Re: Objection to MP08-0244 MOD 1 Modification Request for Mixed Used Development at 23-37 Lindfield Avenue and 11 Havilah Lane, Lindfield.

3 SHADOW DIAGRAM - 21stDEC_3PM
5003 SCALE1 : 650

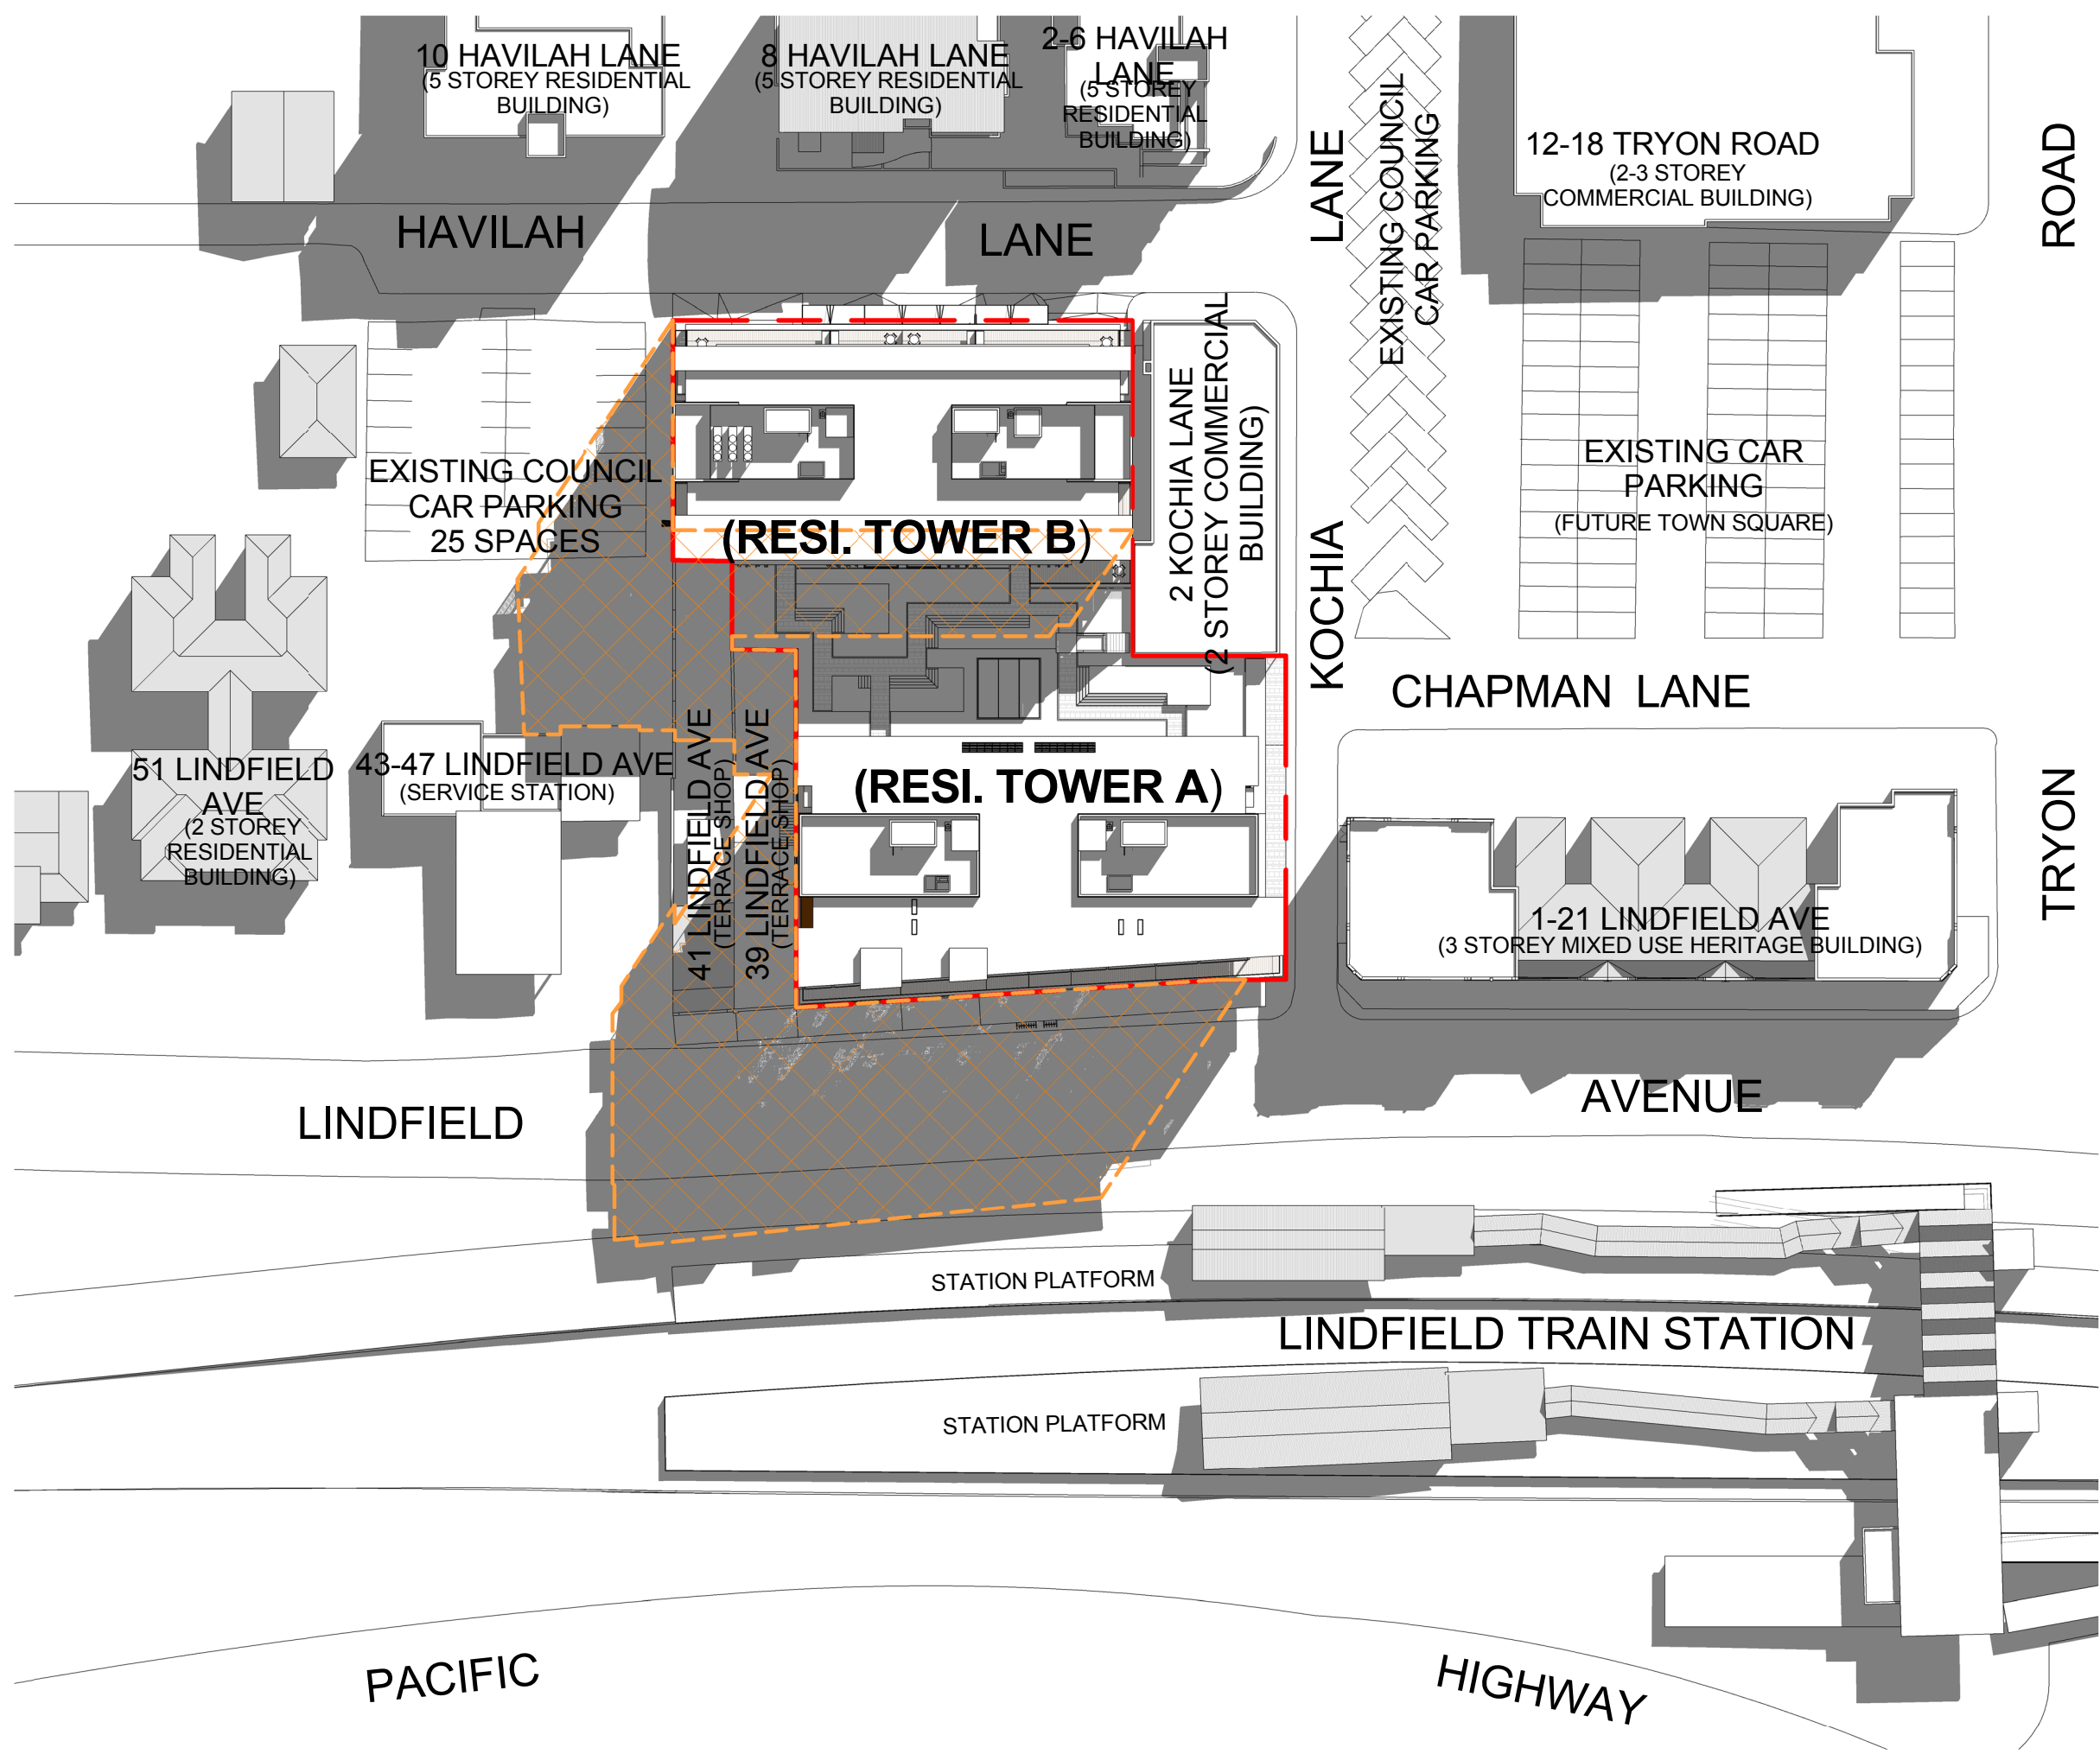
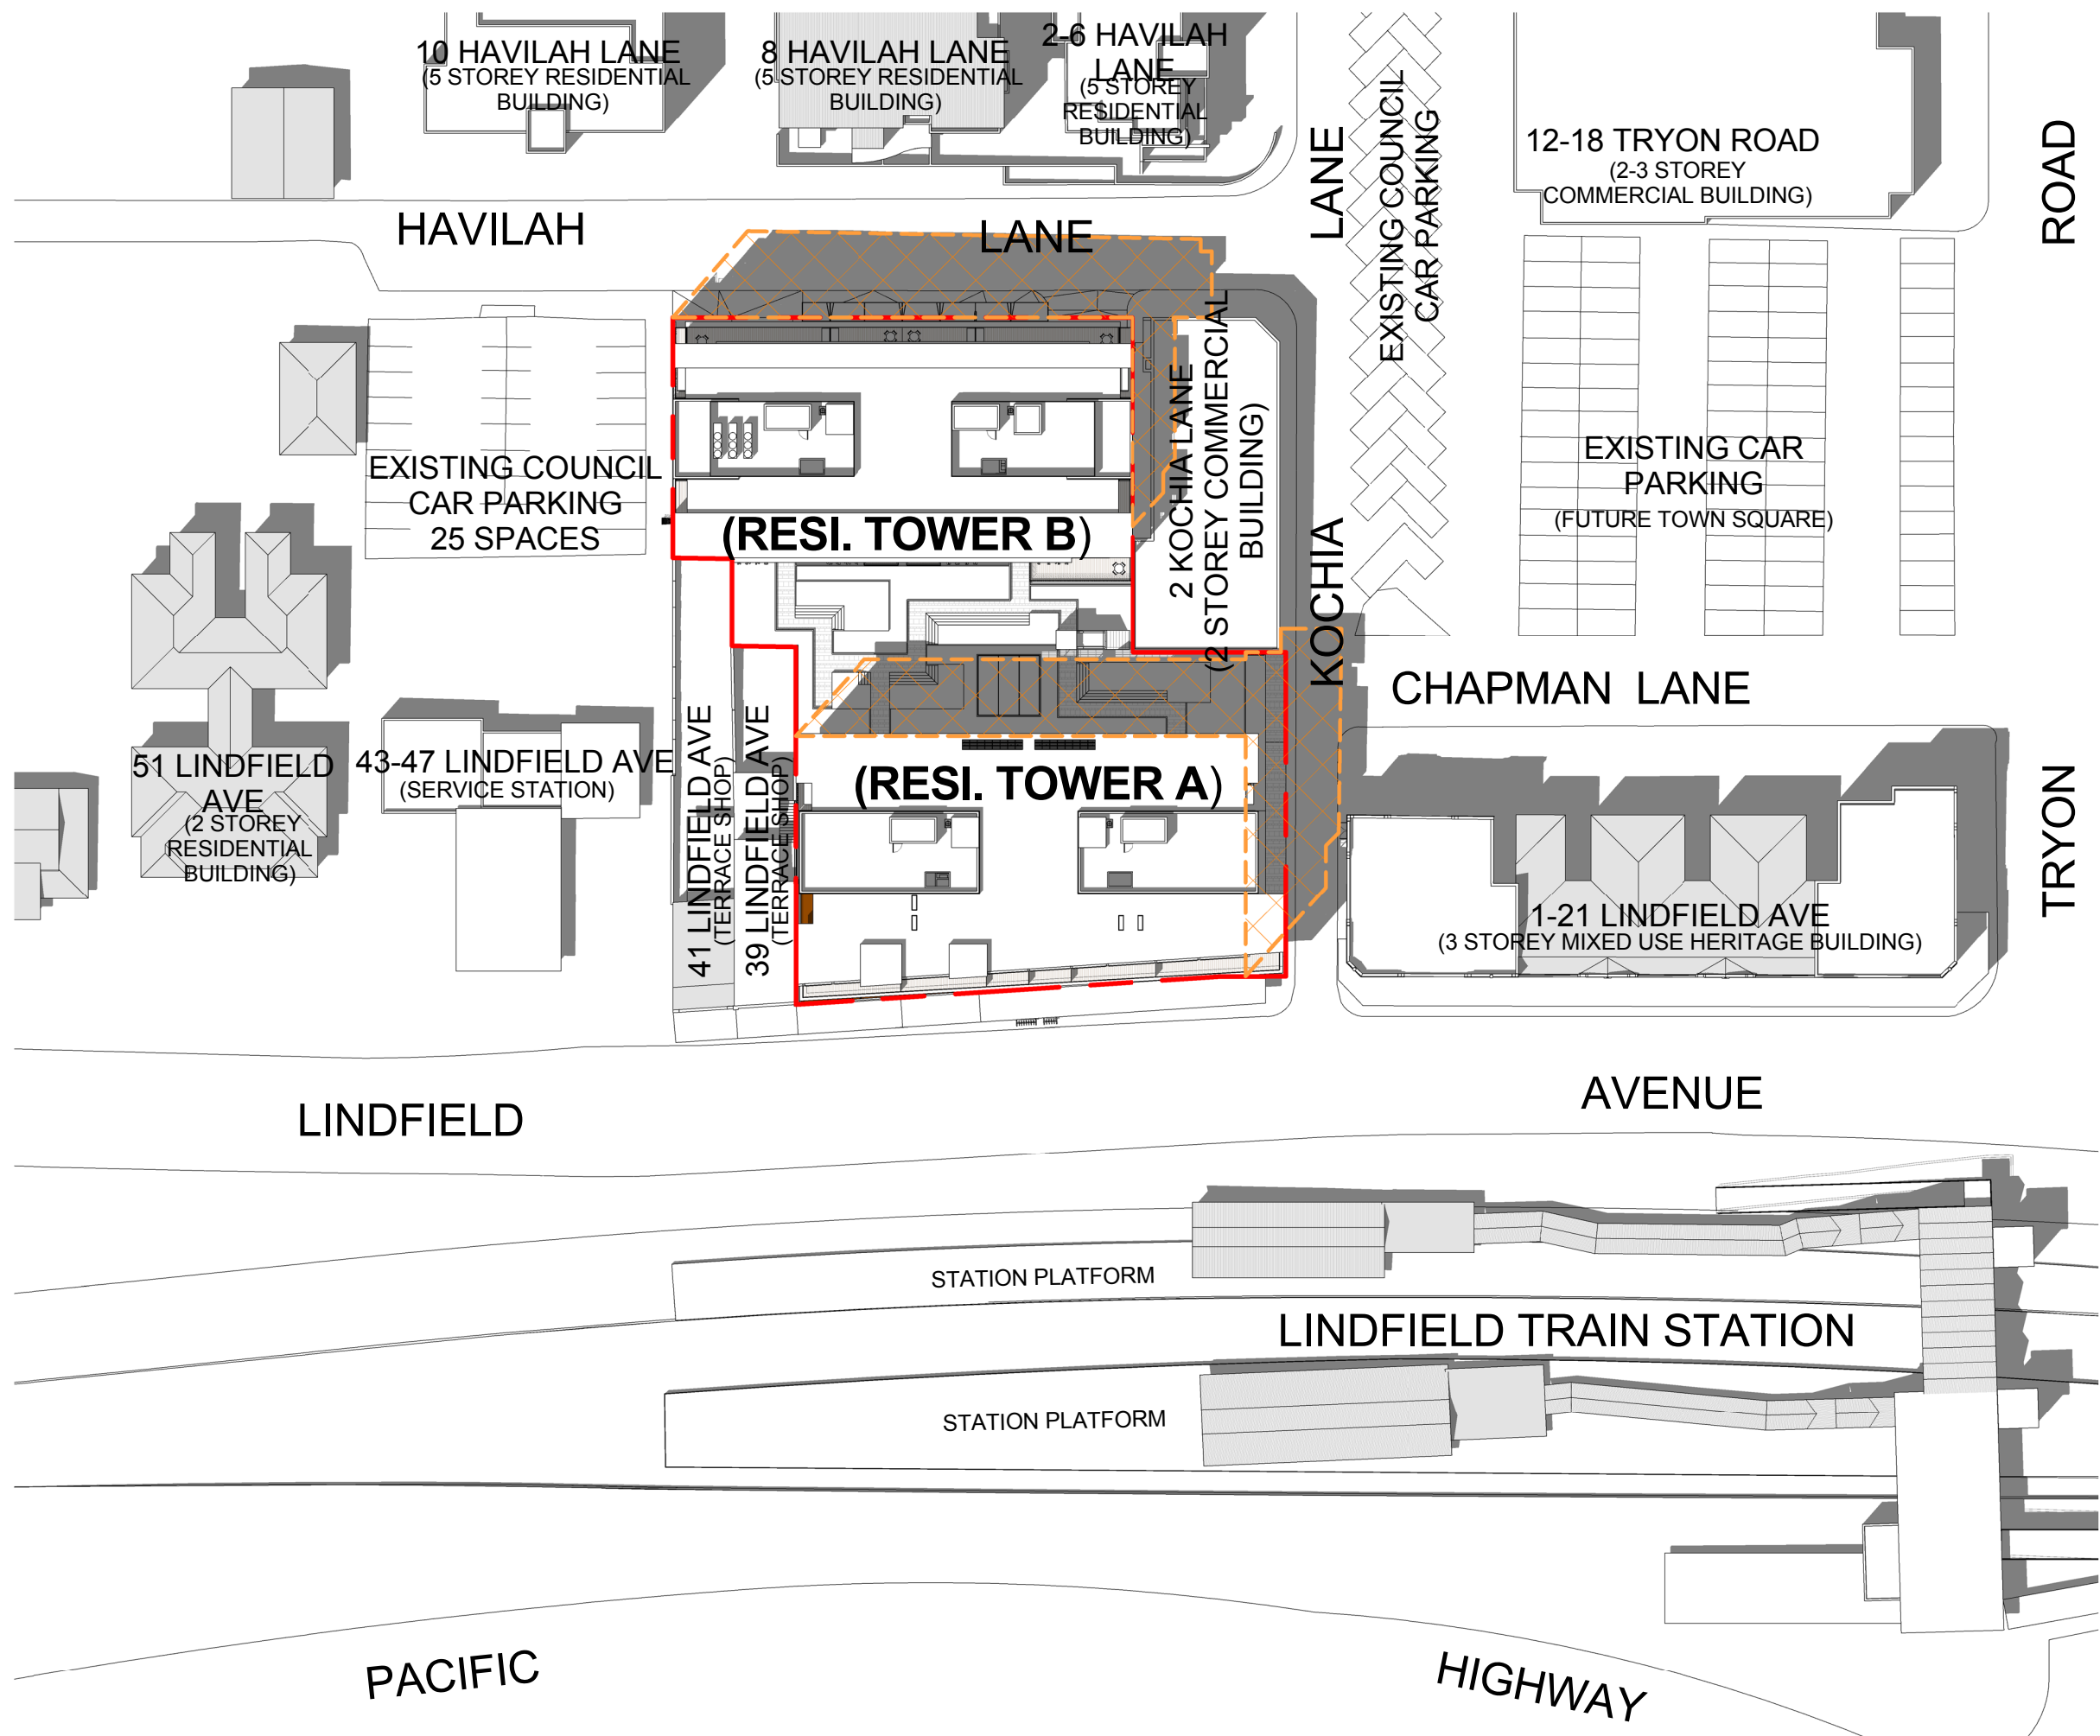
The additional storeys create new adverse shadowing: a) for residents of Havilah Lane apartments particularly after 3pm. B) for the shops surrounding the car park. c) shadowing will also occur for 75% of the year on the rail platform.
